Reference:      Engineering Services  
                    553 Bumpas Creek Rd. Dunn, NC  
                    Project No.: DRB2501-0243\_B

- 1) New Beam/wall connection at exterior wall

Main Level
Existing

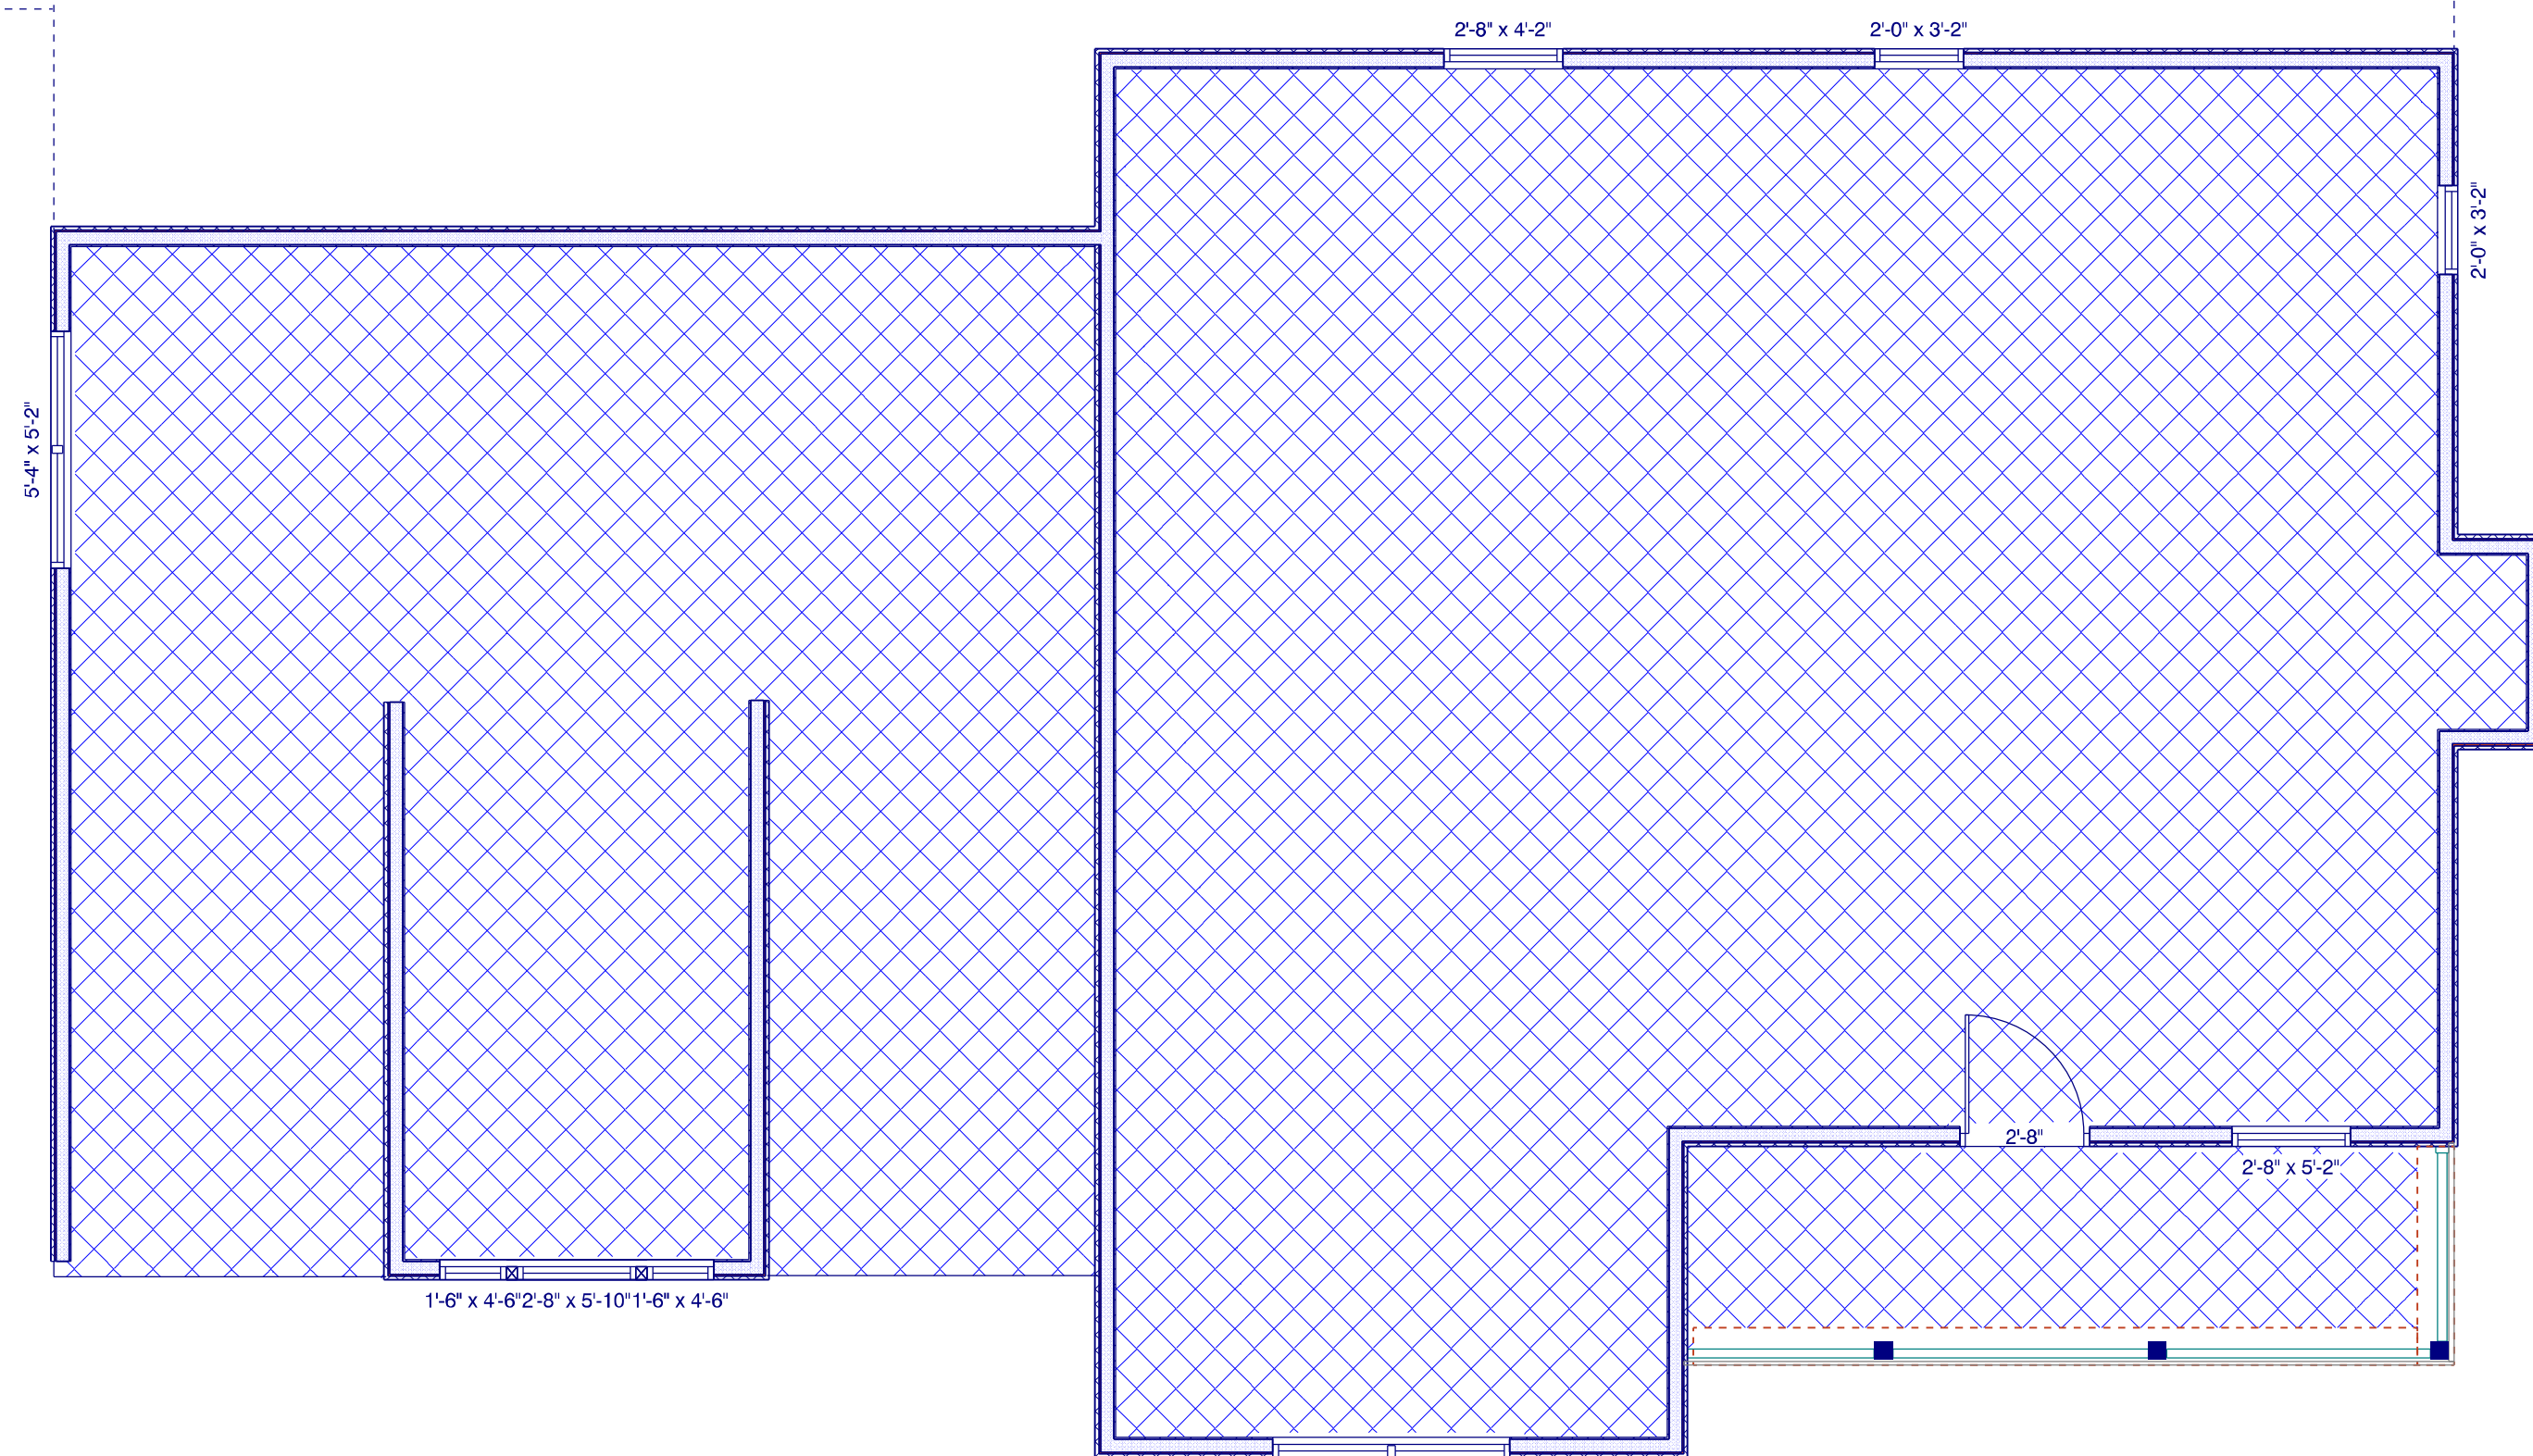
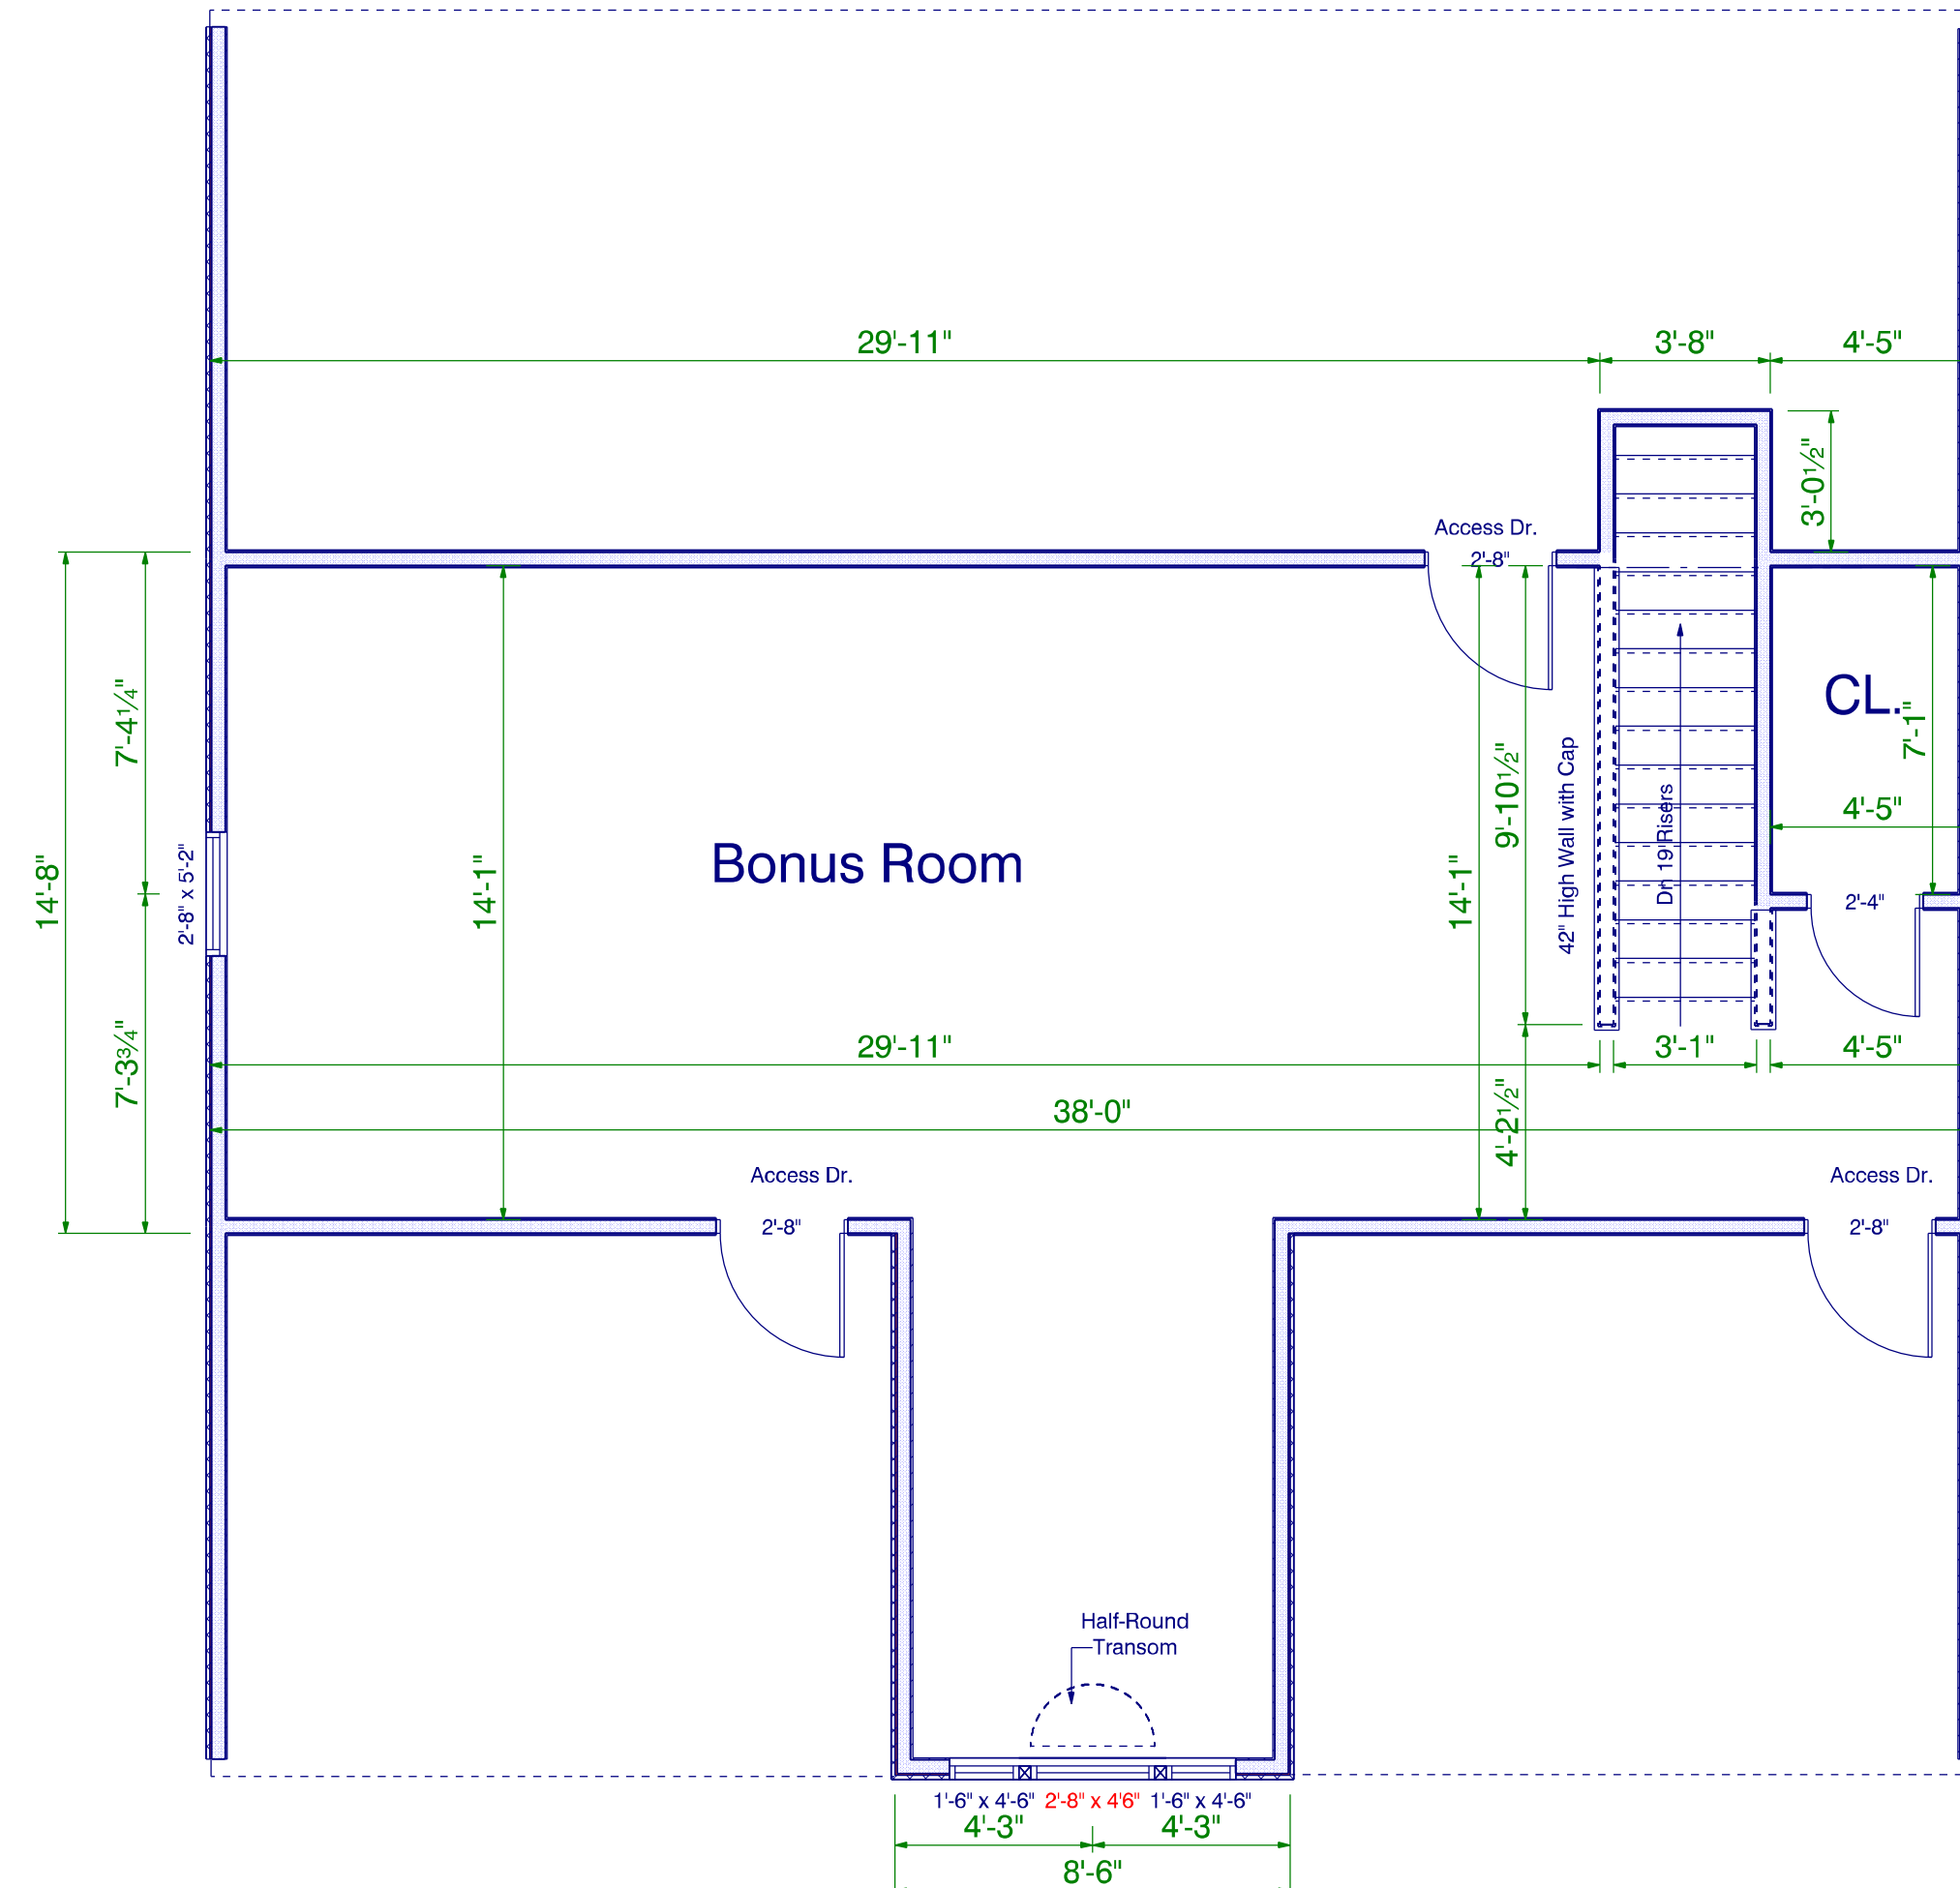
- 1) Based on our plan review and analysis, the new (2) 20" LVL is to be secured to the wall as per Figure 1 on Page 2. The reader is referred to Figure 2 on Page 3 for location clarification. The builder is to ensure that the new beam bears on an LVL bearing plate on (6)2x4 studs each end (OR) directly on top of a 3-1/2"x5-1/4" PSL column. If the PSL column option is used, the builder is to ensure that the broken top plate is secured with Simpson CS16 straps.
